18 May 2012

Attention: Director, Infrastructure Projects
Application No.: SSI-5100

[REDACTED] Submission – Environmental Impact Statement North West Rail Link

Figure 10.11 Location of sensitive receivers near Cudgegong Road Station and Tallawong Stabling Facility

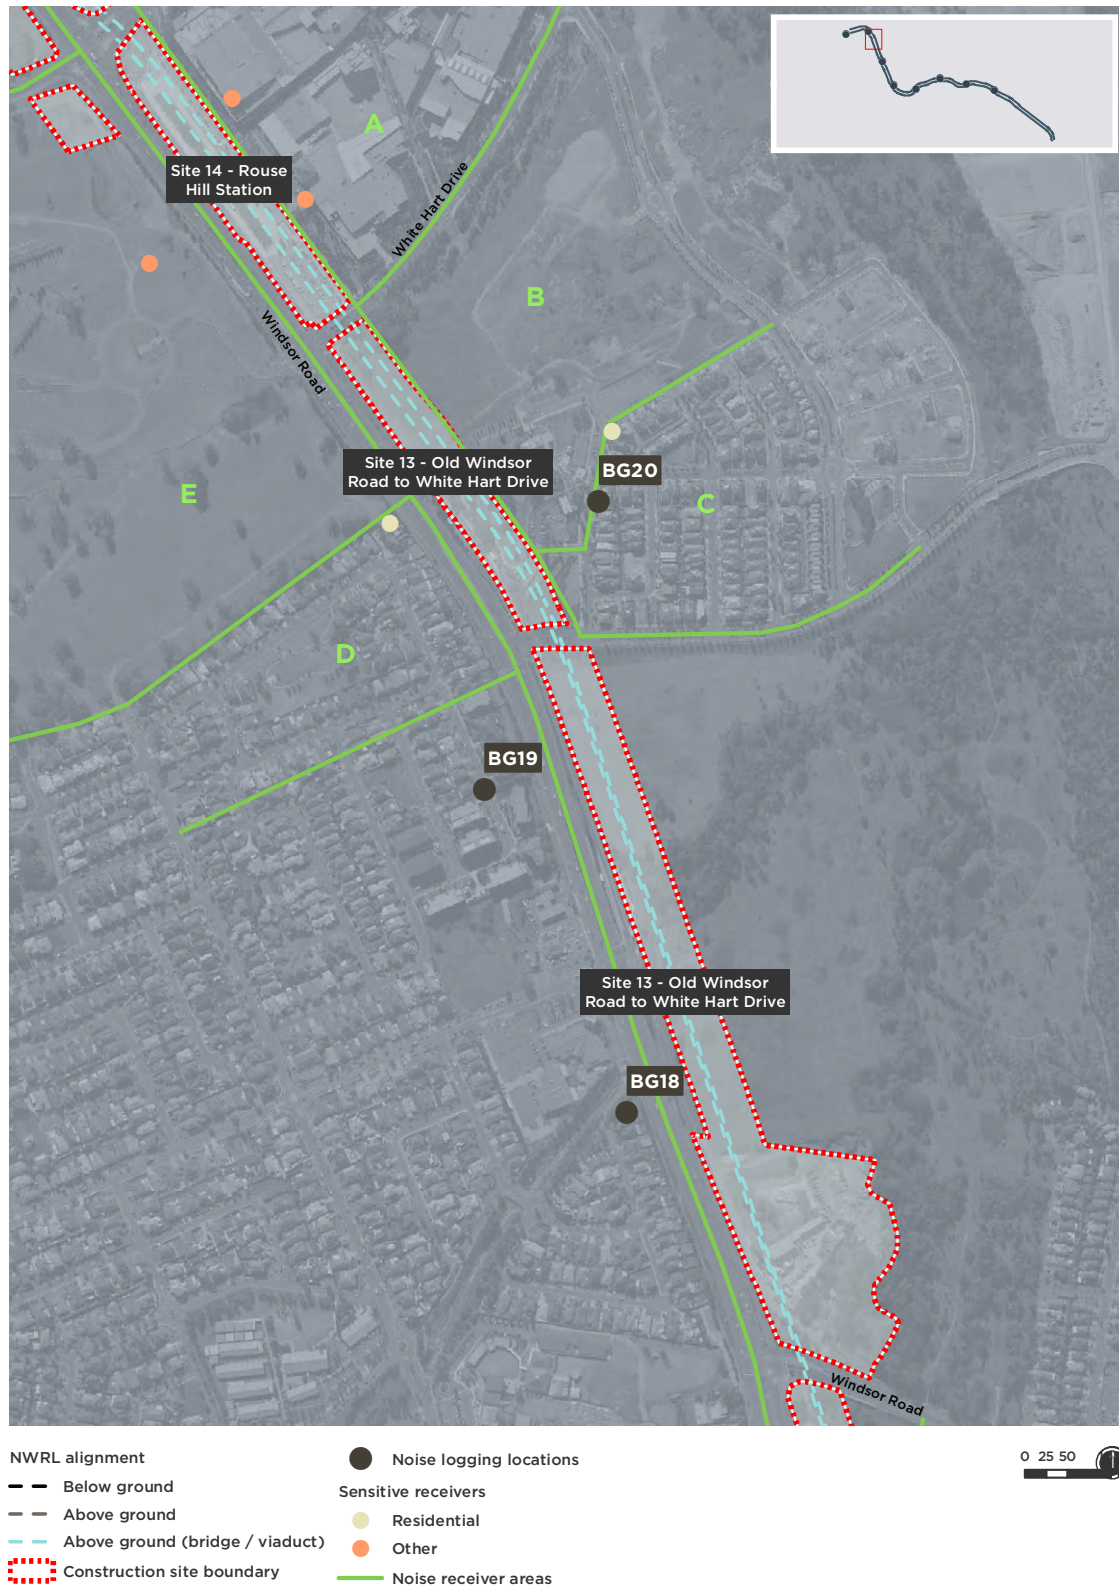
██████████ raises concerns on behalf of the future residents regarding being noise receptors during the construction phase and more critically during the on-going operation of the constructed railway stabling facility. Significant noise impacts to adjoining residential land maybe associated with the Tallawong stabling facility in its proposed location.

The main area of interest to ██████████ is the proposed development of the Tallawong stabling facilities in the far north west of the proposal. The Tallawong stabling facility will be located in a shallow cutting and will have the capacity to stable 16 eight car train sets with the provision for later expansion to 24 eight car train sets.

██████████ raises concerns regarding noise to nearby residents during construction as well as on-going operational noise impacts. Whilst ██████████ acknowledges that a major infrastructure project of this size will create noise impacts during the long construction phase, measures to mitigate and minimise noise to adjoining residents is crucial.

In terms of construction noise, Section 10 Key Issues Table 10.33 *Summary of noise and vibration mitigation measures* proposes that the only measure to mitigate construction noise in and around the Tallawong stabling facility during construction is the standard mitigation measures, as outlined in the Construction Noise and Vibration Study. [REDACTED] requests further consideration is given to more specific measures to mitigate construction noise to the proposed residential areas surrounding the Tallawong stabling facility site.

The second area of concern is the on-going operational noise issues associated with the Tallawong stabling facility. The current EIS is devoid of any detail to measure, manage or mitigate the noise associated with the long term operations associated with the stabling facility. It is noted within the current EIS that issues pertaining to all operational noise associated with the stabling facility will be addressed in the 2nd EIS due for release in the latter half of 2012. On-going operational issues include: noise from day to day work activities; air conditioning units; brake testing; and horn testing.

In terms of on-going operational noise issues, the future horn testing within the Tallawong stabling facility is a major concern given the historical issues associated with other metropolitan stabling yards within built up residential areas. It is hoped that significant consideration is given in the 2nd EIS to measures to be implemented to mitigate any potential noise impacts associated with the on-going stabling facility in this location with particular regard to the potential options for reducing or eliminating the noise impact of horn testing.
